Phone: 0300 123 6780  
Email: [developeras@lancashire.gov.uk](mailto:developeras@lancashire.gov.uk)  
Your ref: 3/2025/0284  
Our ref: 3/2025/0284/HDC/KW  
Date: 22 May 2025

**Location:** Little Town Farm Chipping Road Thornley PR3 2TB  
**Proposal:** Proposed alterations to vehicular access from Chipping Lane to include widening of access track, creation of pedestrian footpath and erection of fencing.  
**Grid Ref:** 360678, 439287

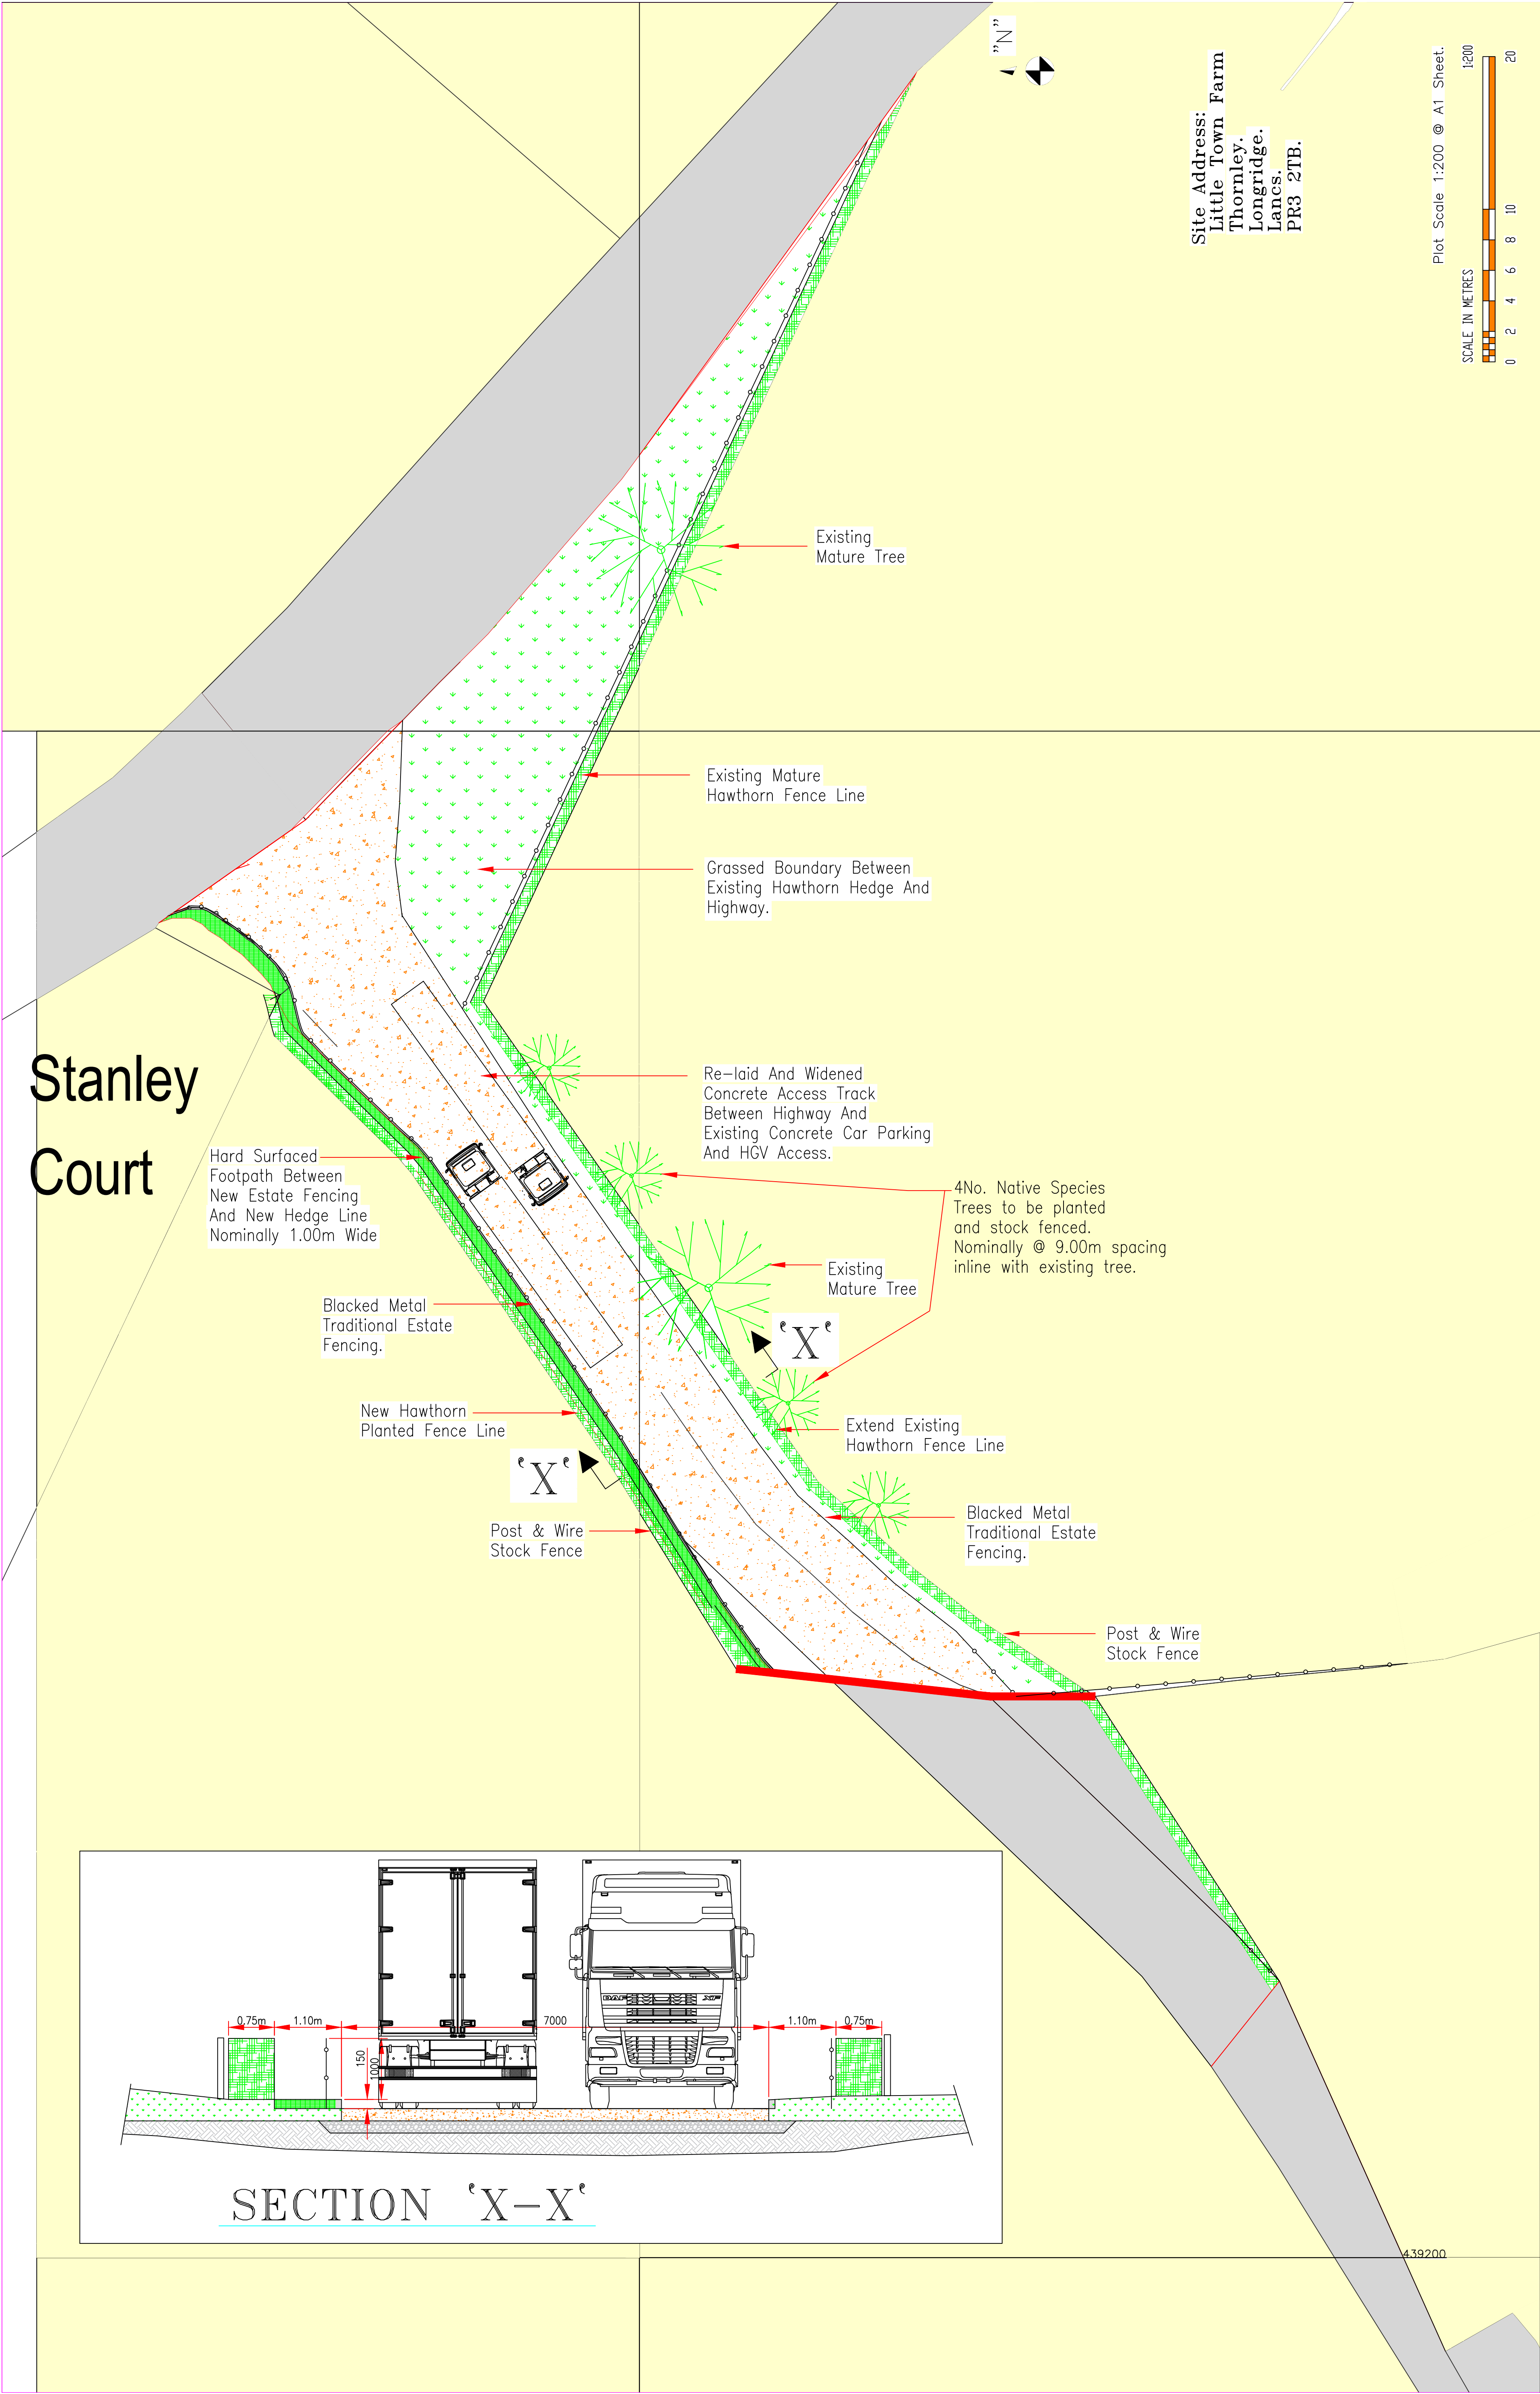
Following improvements to the width of the access, the access should be joined flush with the adopted highway as currently the access is poorly joined. The access should also include drainage whilst improvements are being made.

The LHA would also expect the access to be hard surfaced, extending from the adopted highway boundary, for a minimum distance of 15m into the site. The surface shall be appropriately paved in tarmac, concrete, block pavements, or other hard material to prevent debris from being deposited onto the highway.

The internal access track is proposed to be a minimum of 7m wide for 66m into the site then appears to widen and provide access to the sites car park.

The LHA are aware that no parking or turning plan has been submitted to support the application. Consideration should be given to a formalised parking and turning area for the largest vehicles accessing the site.

The proposal also includes an improved pedestrian access, providing a separate dedicated route into the site from the access along the site access, the proposal is 1m wide; the Public Right of Way will be retained along the existing footpath line but the footway will provide an alternative route away from traffic should walkers wish to take an alternative route away from traffic. The LHA should note that in line with Inclusive Mobility guidelines footways should be designed to accommodate all pedestrians, including those with mobility impairments, as such the footway should be at least 2m wide and if the footway is obstructed, the LHA would accept 1m in width for a maximum of 6m.

For safe pedestrian access from the access to the car park, the footway should continue until it meets the car park and a pedestrian crossing facility should be provided over the internal track.
